**RE: Project Approval 06_0074 Modification Request No. 5
Boral Peppertree Quarry - Marulan**

Attachment A – EPA Comments – Peppertree Quarry Mod 5

The EPA has reviewed the noise impact assessment contained within the EA, titled 'Noise Impact Assessment – Peppertree Quarry Mod 5' (NIA), prepared by Wilkinson Murray and dated September 2018.

Figure 3: Noise Receivers

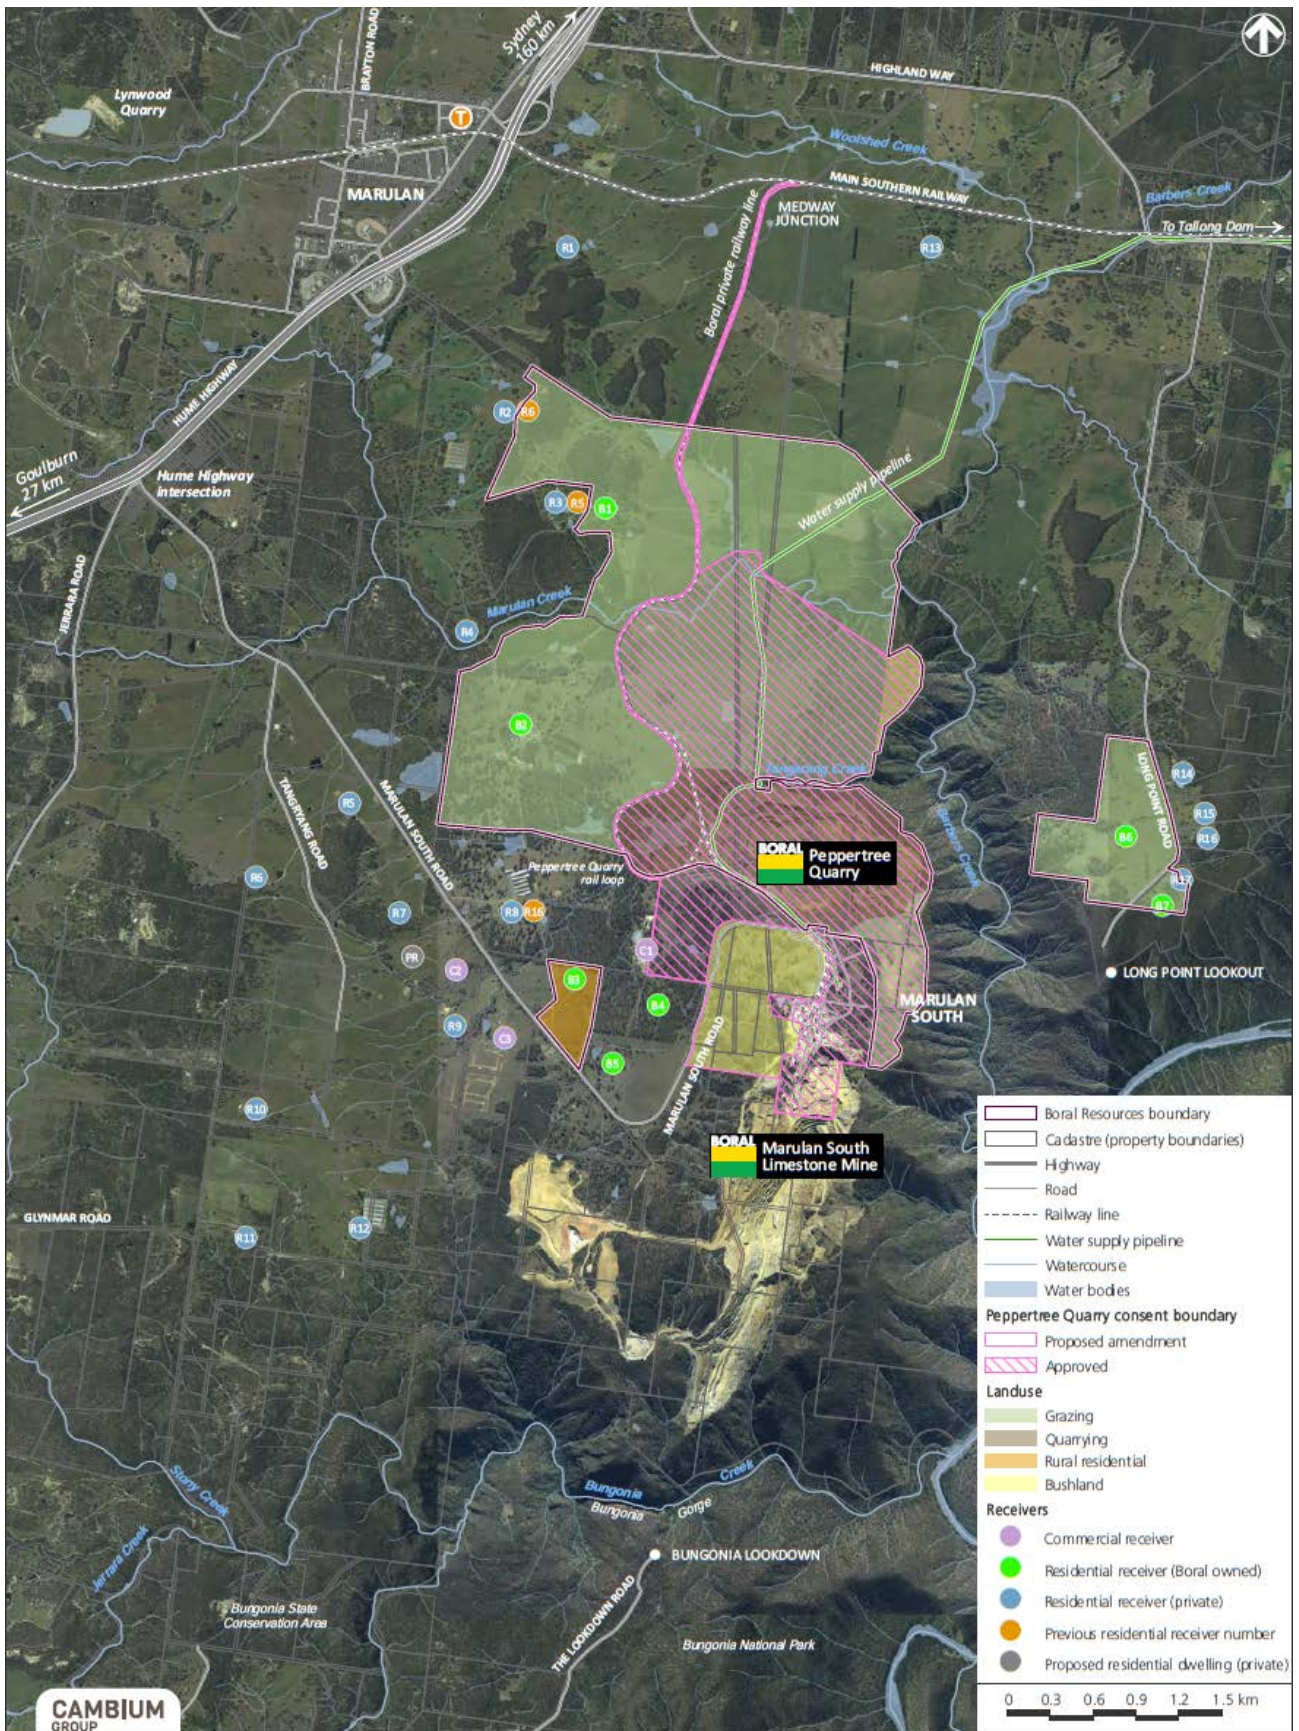
- L6.1** Noise generated at the premises must not exceed the noise limits at the times and locations in the table below. The locations referred to in the table below are indicated by Appendix 3 of the Consolidated Project Approval (06_0074 Mod 4). **<Proponent to check all references and Lot/DP numbers for accuracy>**

Location	Noise Limits in dB(A)			
	Day	Evening	Night	Night
	L _{Aeq} (15 minute)	L _{Aeq} (15 minute)	L _{Aeq} (15 minute)	L _{AFmax}
R3 (5) - 113 Green Hills Road Marulan (Lot 2, DP 1060897)	40	35	35	52
R2 (6) - 90 Green Hills Road Marulan (Lot 11, DP 881240)	40	35	35	52
R8 (16) - 381 Marulan South Road, Marulan (Lot 1, DP 1190667)	40	35	35	52
Any other noise sensitive residential receiver location	40	35	35	52
